Ribble Valley Borough Council
Housing & Development Control

Application no: **3/2021/0955**

Address: **Old Sawley Grange Gisburn Rd Sawley BB7 4LQ**

Proposal: **Change of use of land from agricultural to proposed offices.**

drawing: Proposed Site Plan

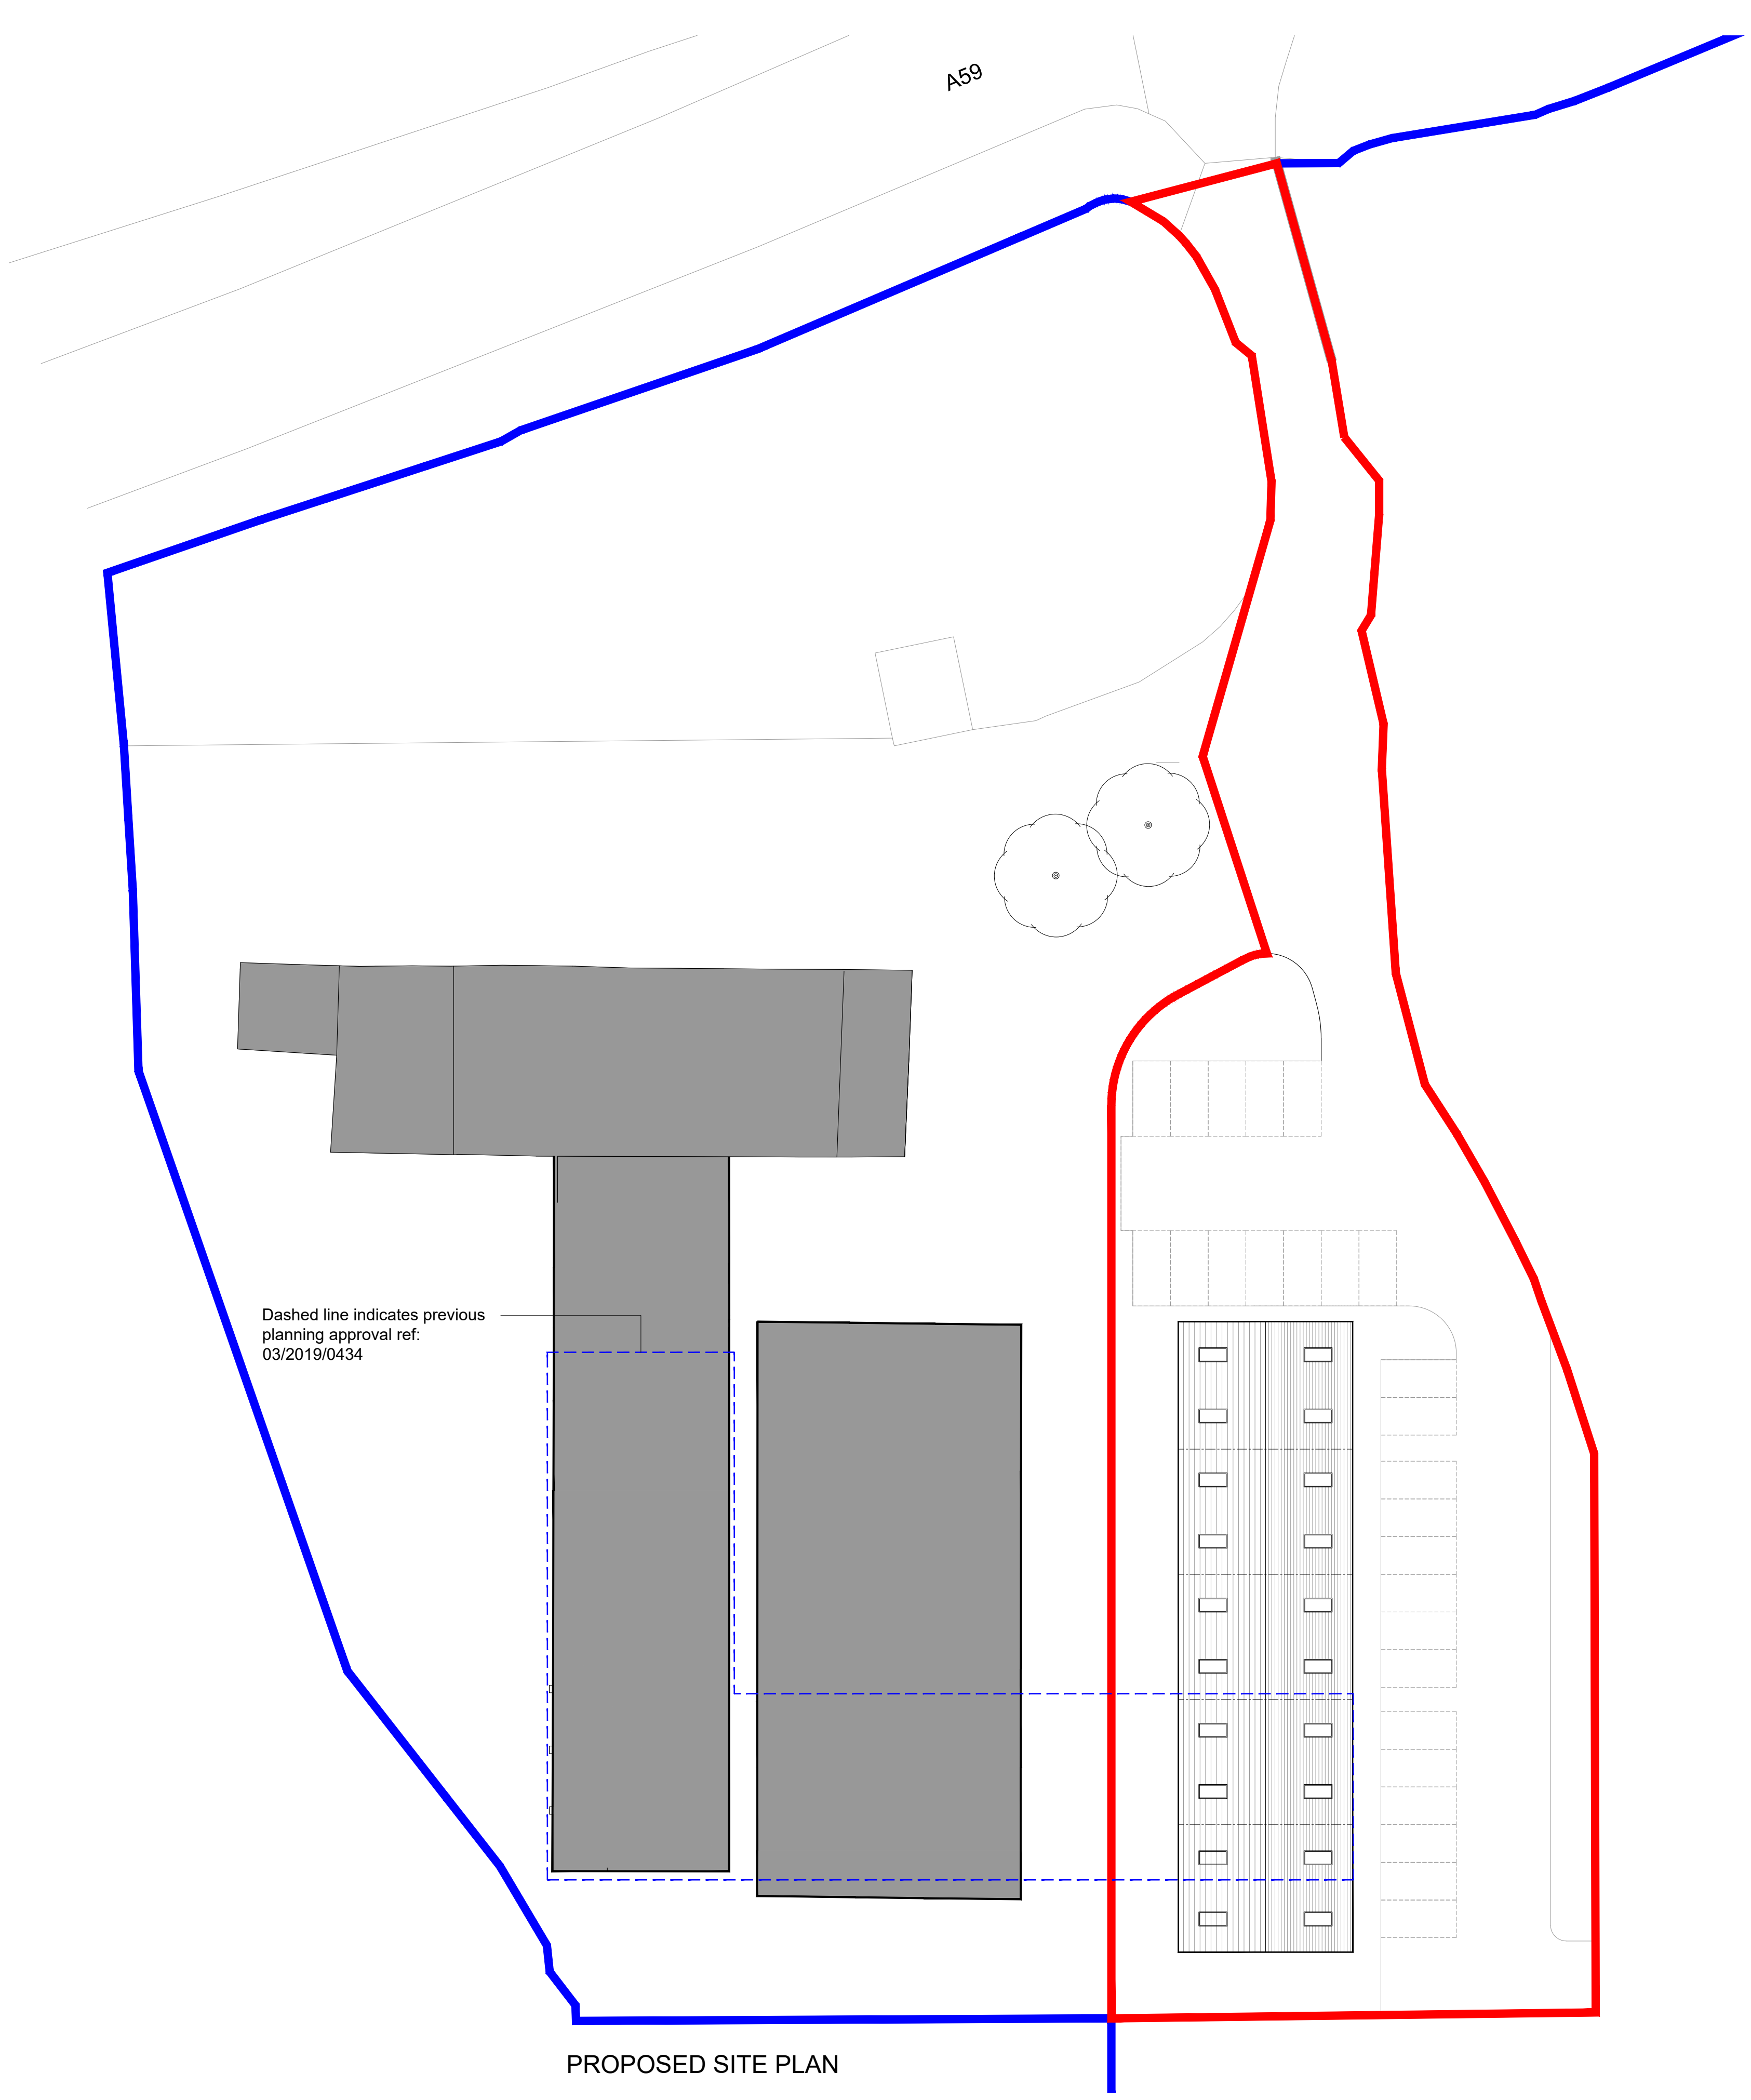
The LHA have reviewed LARK drawing number 102 titled "Proposed Site Plan" and understands that 26 car parking spaces will be provided for the 580sqm internal floor area of the proposed offices. This complies with the parking standards as defined in the Joint Lancashire Structure Plan and so have no further comments to make regarding parking.

The LHA are aware that Public Footpath 3-39-FP18 goes through the site and conflicts with the proposed office building. However, the LHA are aware that application reference 3/2019/0434 which was also for a proposed office block also conflicted with the Public Footpath. Therefore, due to this reason the LHA are unable to object against the building obstructing the Public Footpath and instead will have to place suitable conditions on the application, as seen below.

4. No part of the development hereby permitted shall be occupied until such time as the access arrangements shown on LARK drawing number 102 have been implemented in full.

5. The development hereby permitted shall not be occupied until such time as the parking and turning facilities have been implemented in accordance with LARK drawing number 102. Thereafter the onsite parking provision shall be so maintained in perpetuity.
